**Consultation Response from KC,
Lead Local Flood Authority**

2023/90237 Park Gear Works, Park Road, Lockwood, Huddersfield, HD4 5DD

Discharge of condition 10 (drainage strategy) of previous permission 2020/91894 for demolition of existing building and erection of engineering building with associated external works

Date Responded: 30/08/2023.

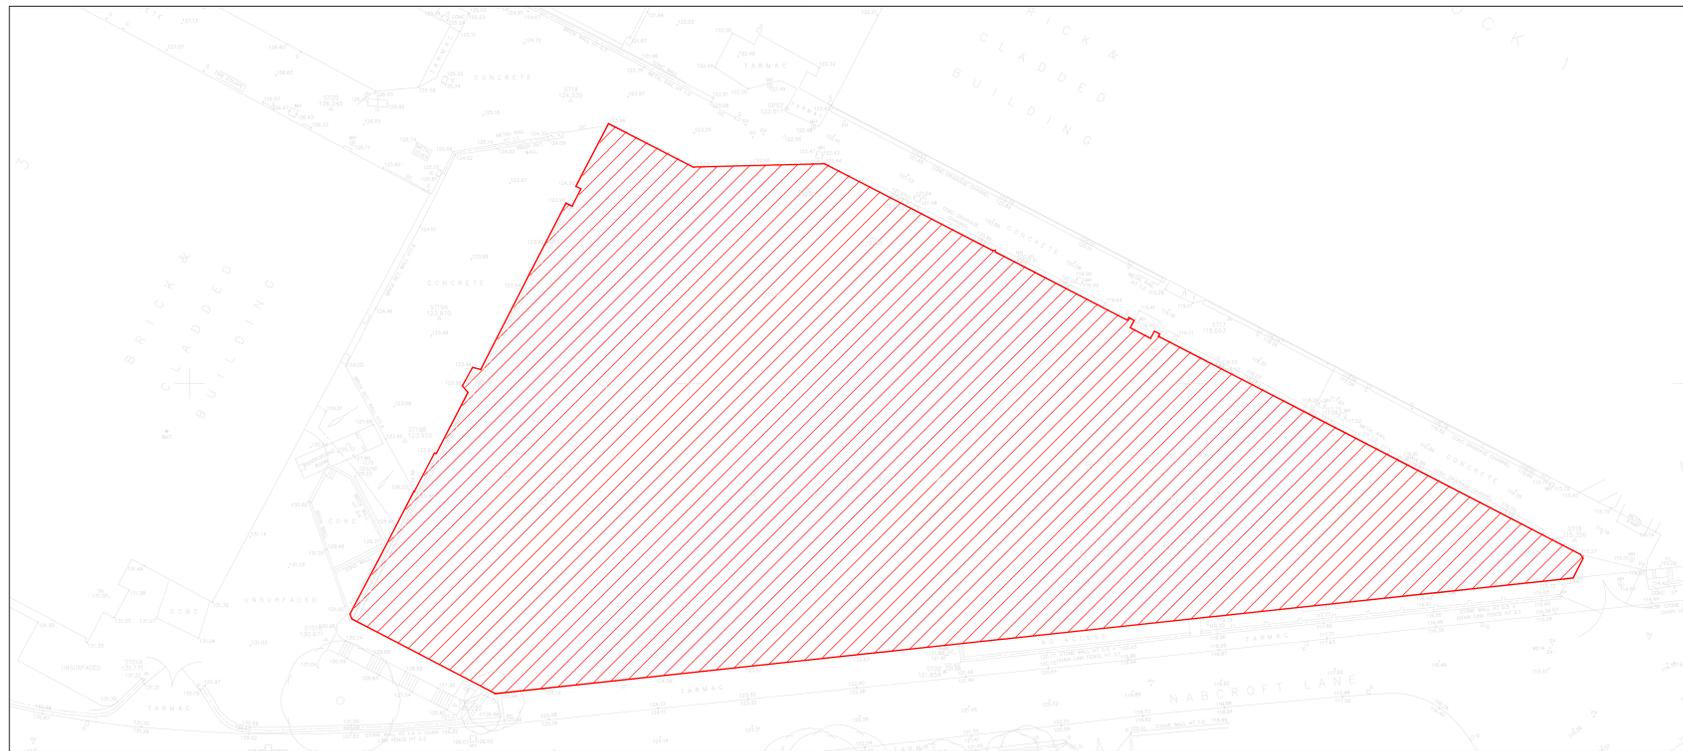
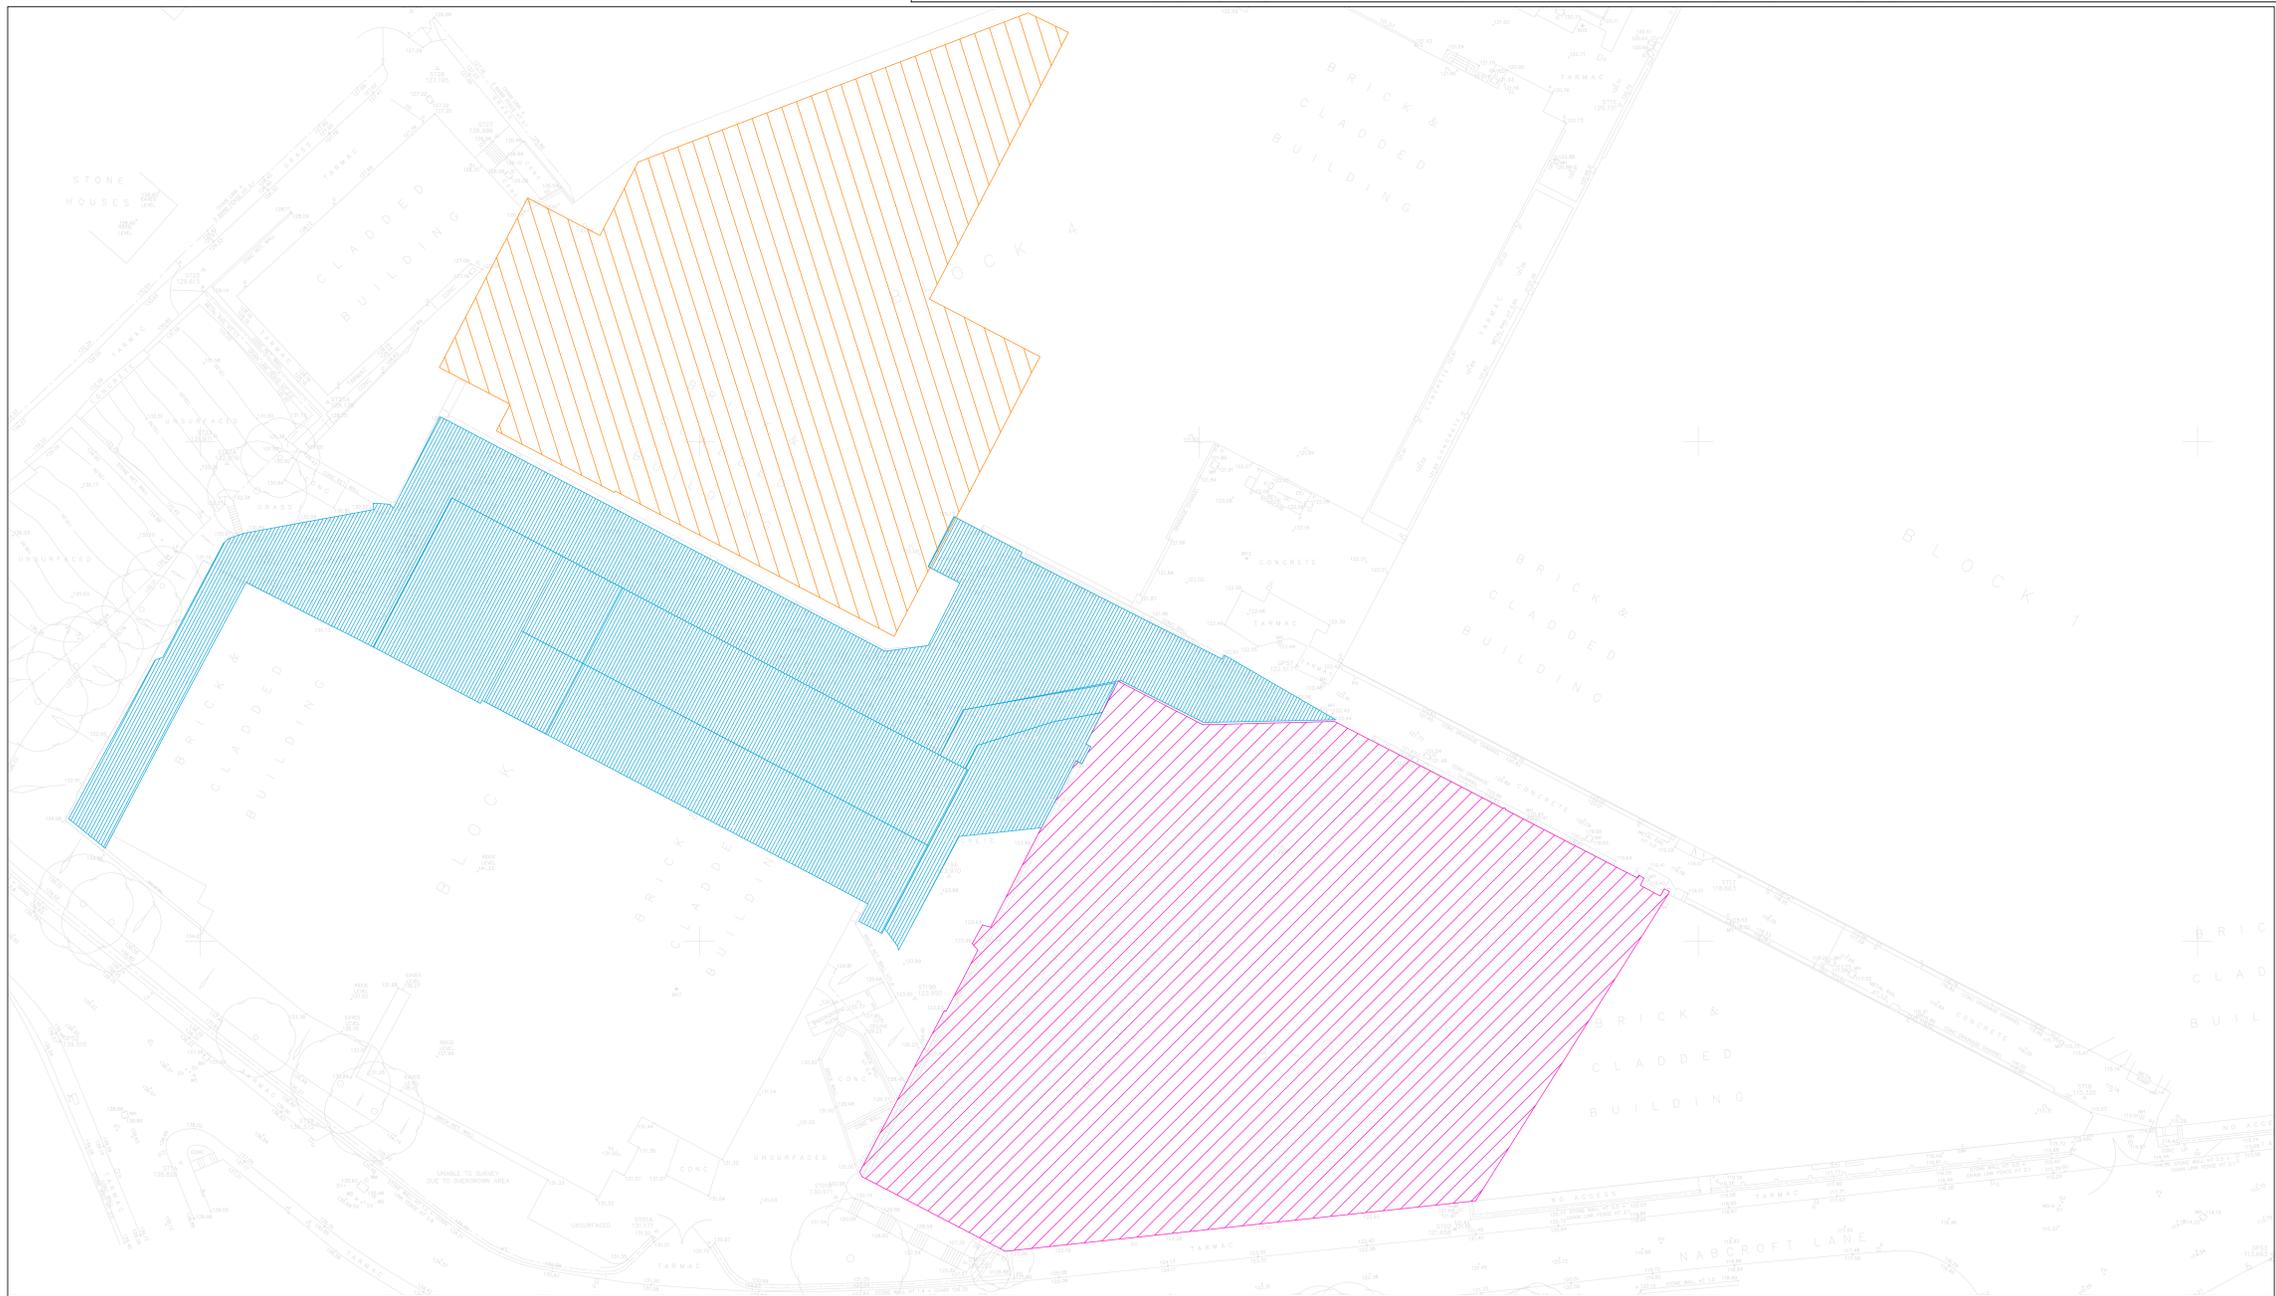
The area used to derive the 71.2l/s discharge rate shown on Drawing DBS-AVE-00-XX-DR-C-0005 is different to the Proposed Impermeable Area shown on DBS-AVE-00-XX-DR-C-1006 (0.949ha) – this discrepancy should be explained further.

Drawing DBS-AVE-00-XX-DR-C-0005 appears to indicate that the area to be demolished is 0.292ha and partially replaced by the new MA4 building – what will happen to the remaining demolished area that is outside of the new building? Is it proposed that this area will drain unattenuated?

Title: Proposed Impermeable Areas
Plan

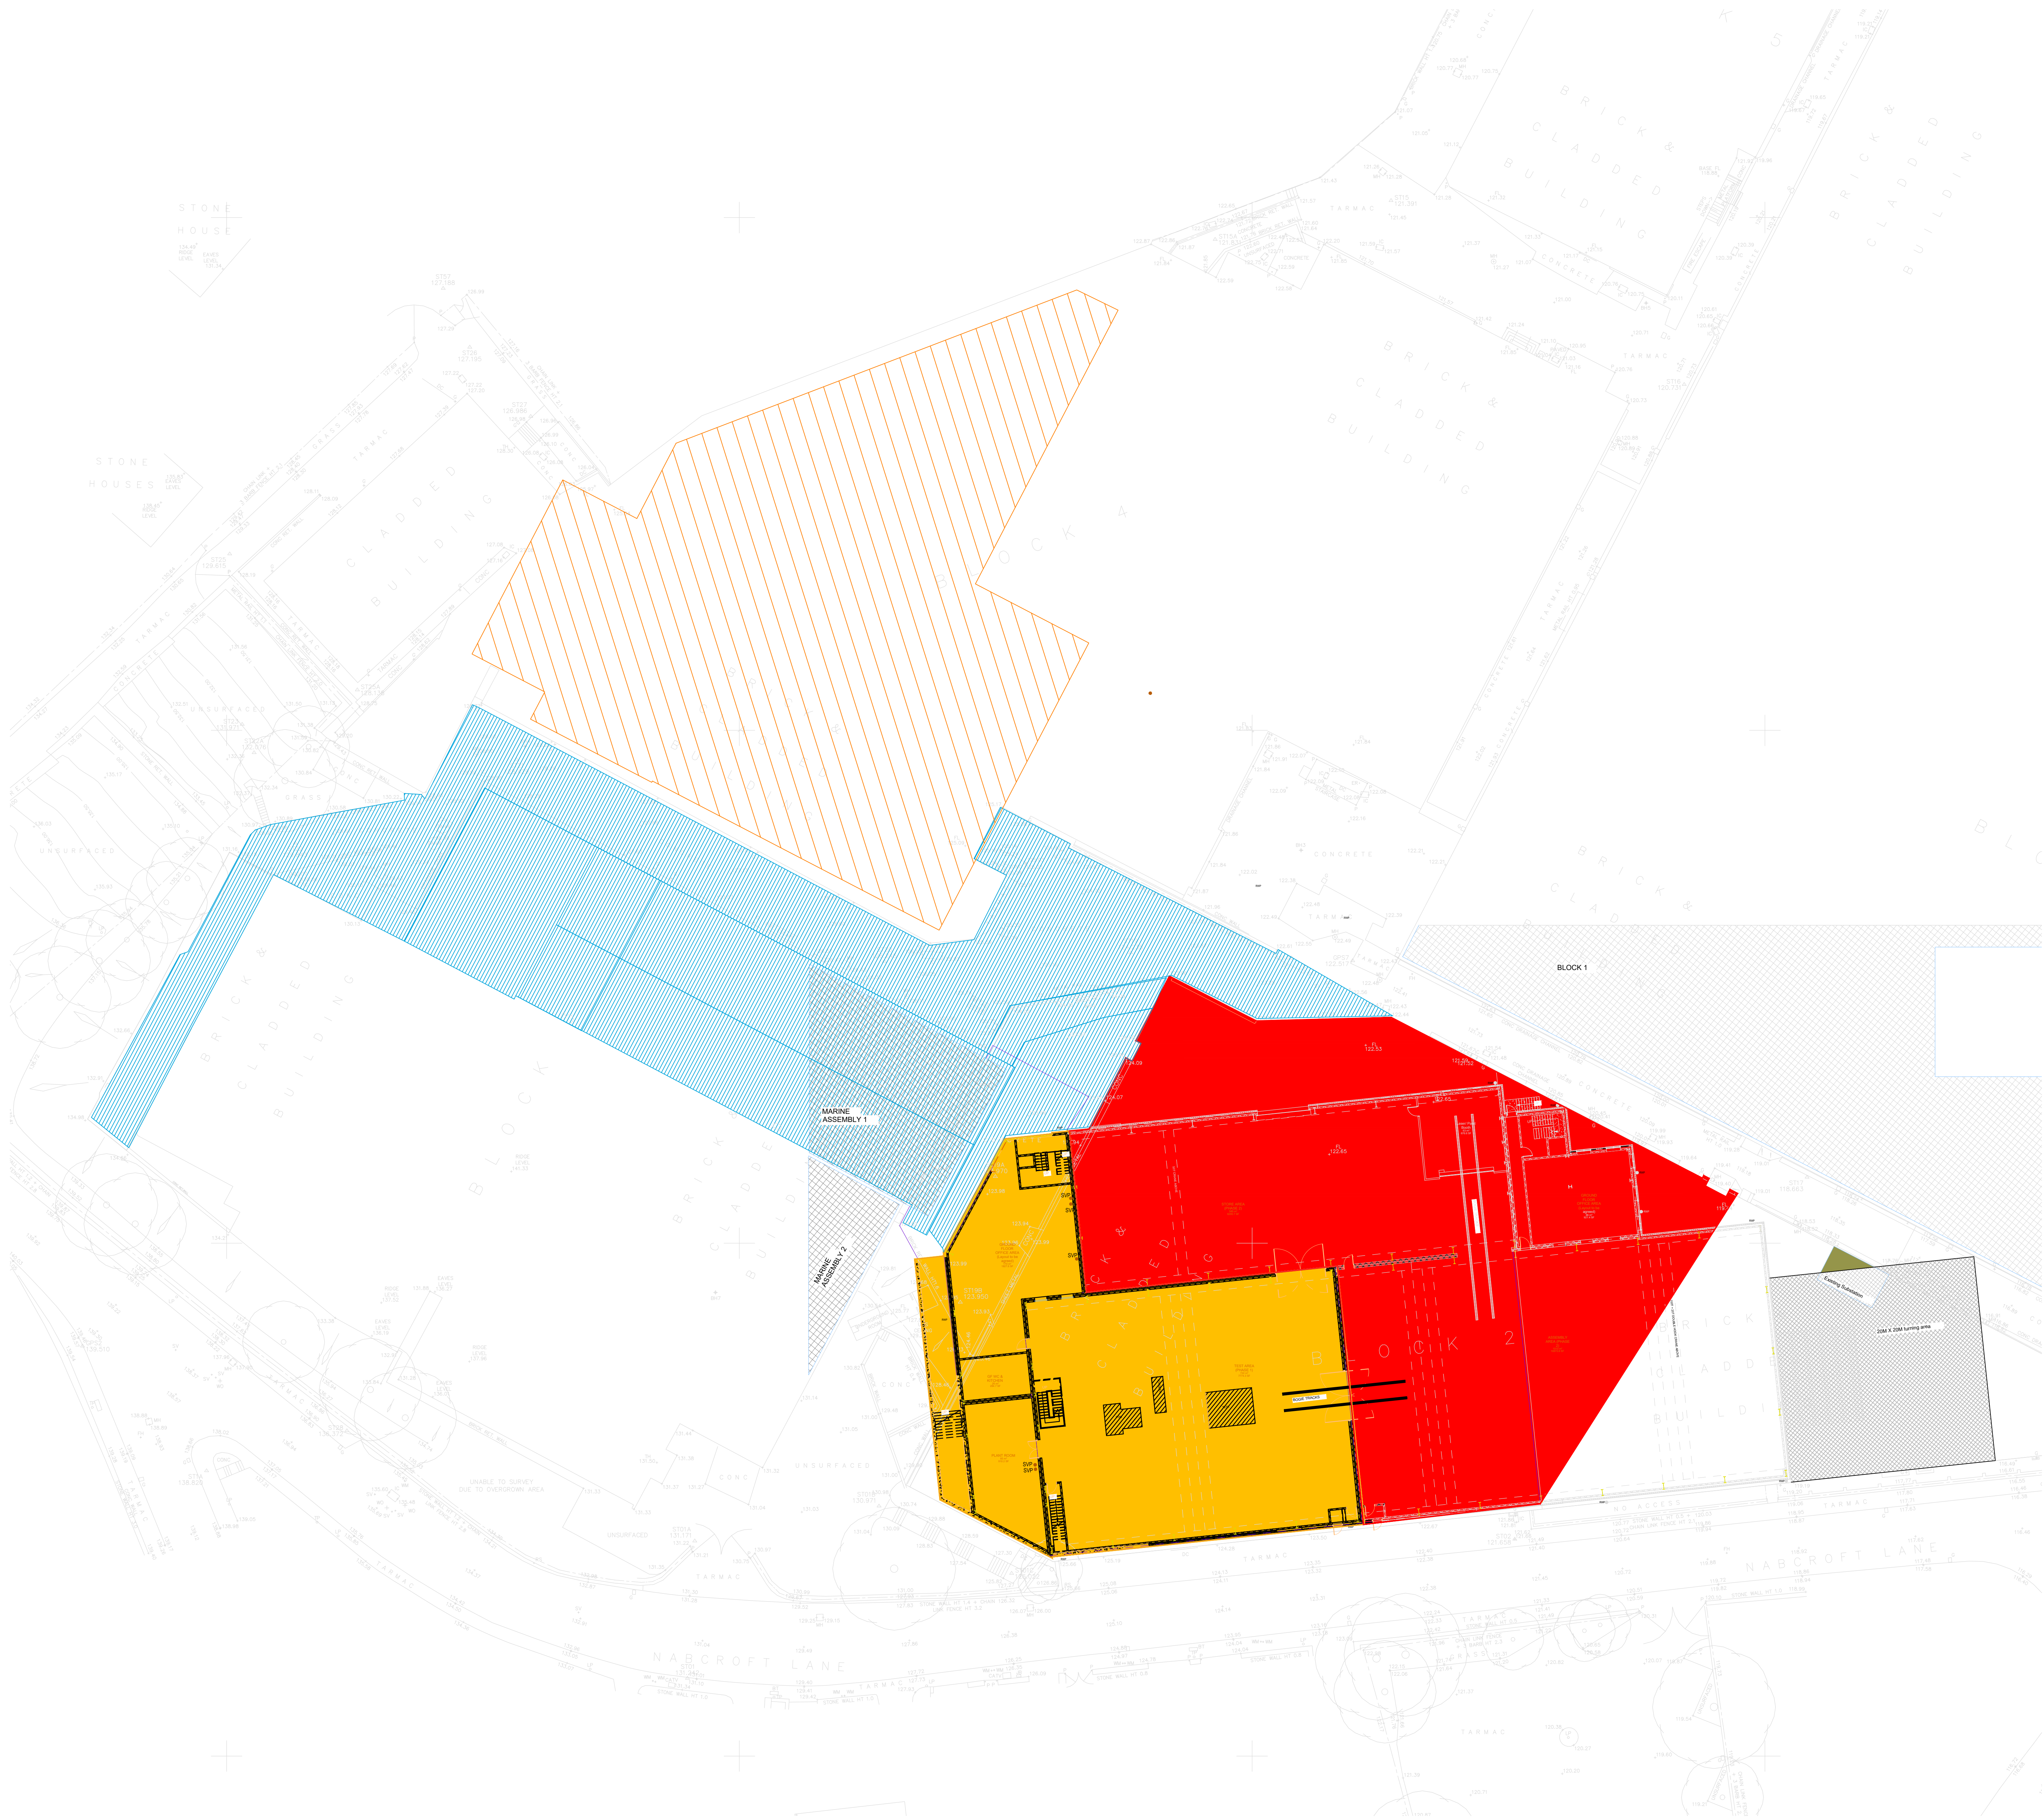
Drawing DBS-AVE-00-XX-DR-C-1006 has a shaded area described as “MA1 Contributing area” but the shading has not appeared on the drawing.
